Our Ref: K/31/18/CLP
Your Ref:

Application for Lawful Development Certificate for a Proposed Use or Development

Development Lawful development certificate for a single storey side extension
Location Weybourne House Golden Acre Kingston

**WEYBOURNE HOUSE, GOLDEN ACRE, EAST
PRESTON LITTLEHAMPTON, BN16 1QR
DRWG WEYBOURNE 011 (A)
PROPOSED REAR ELEVATION
SCALE 1:100 @ A4
CERTIFICATE OF LAWFULNESS PROPOSED
AUGUST 2018**

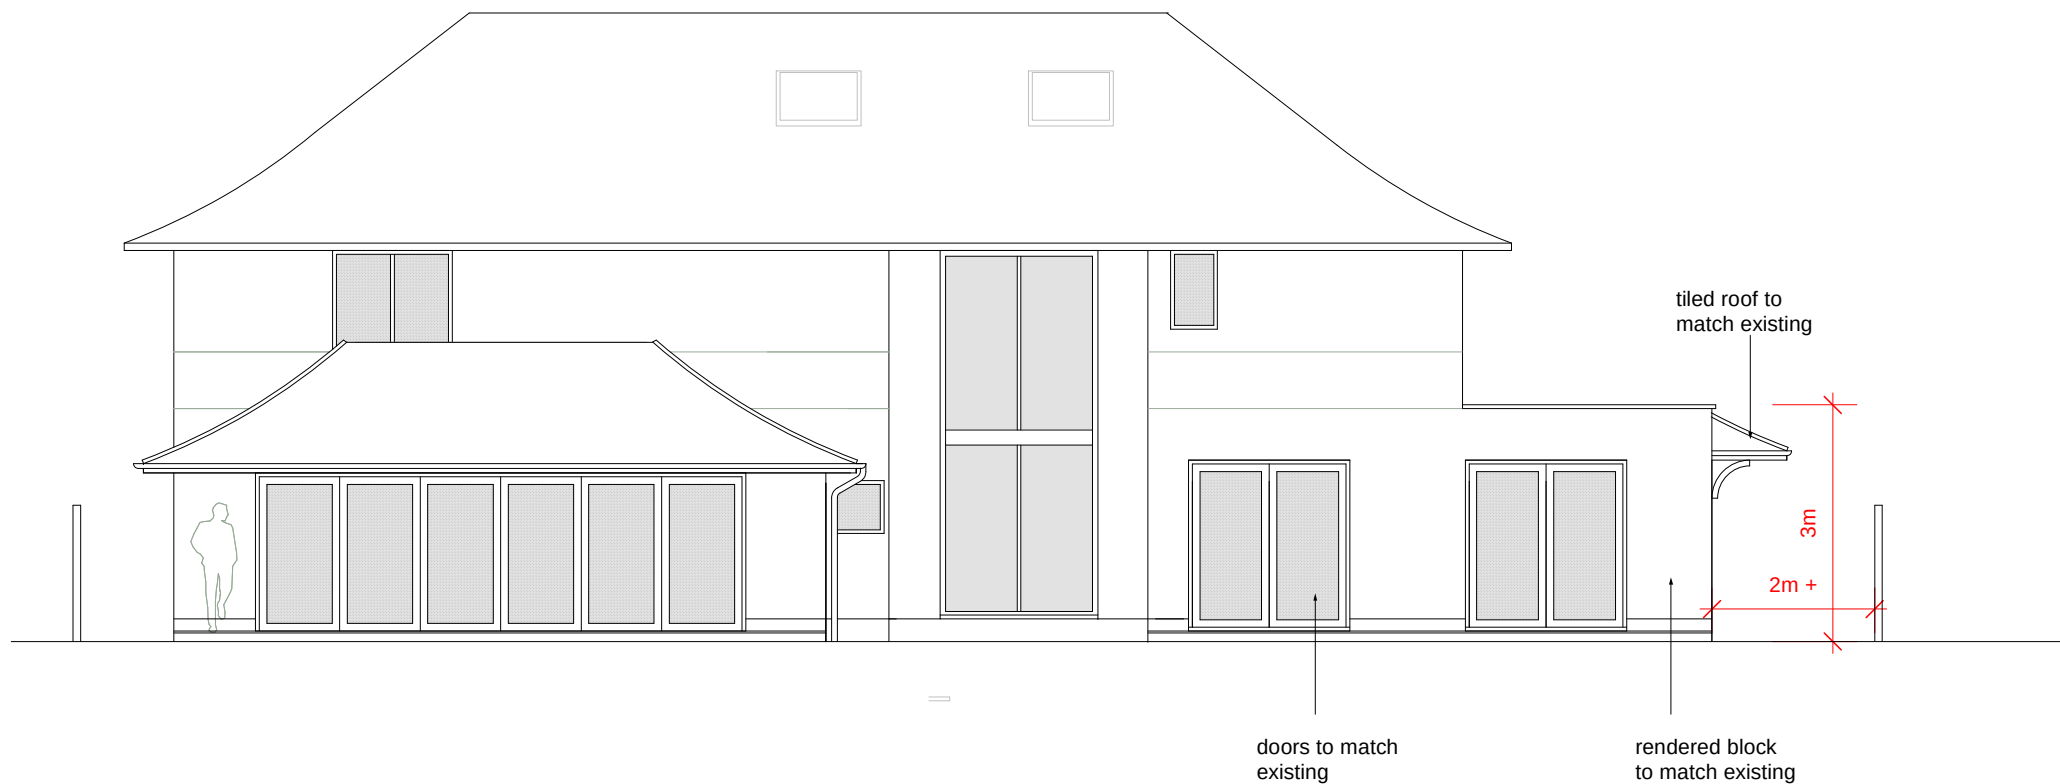
The existing ground floor plan and rear elevation do not accord. Please amend accordingly.
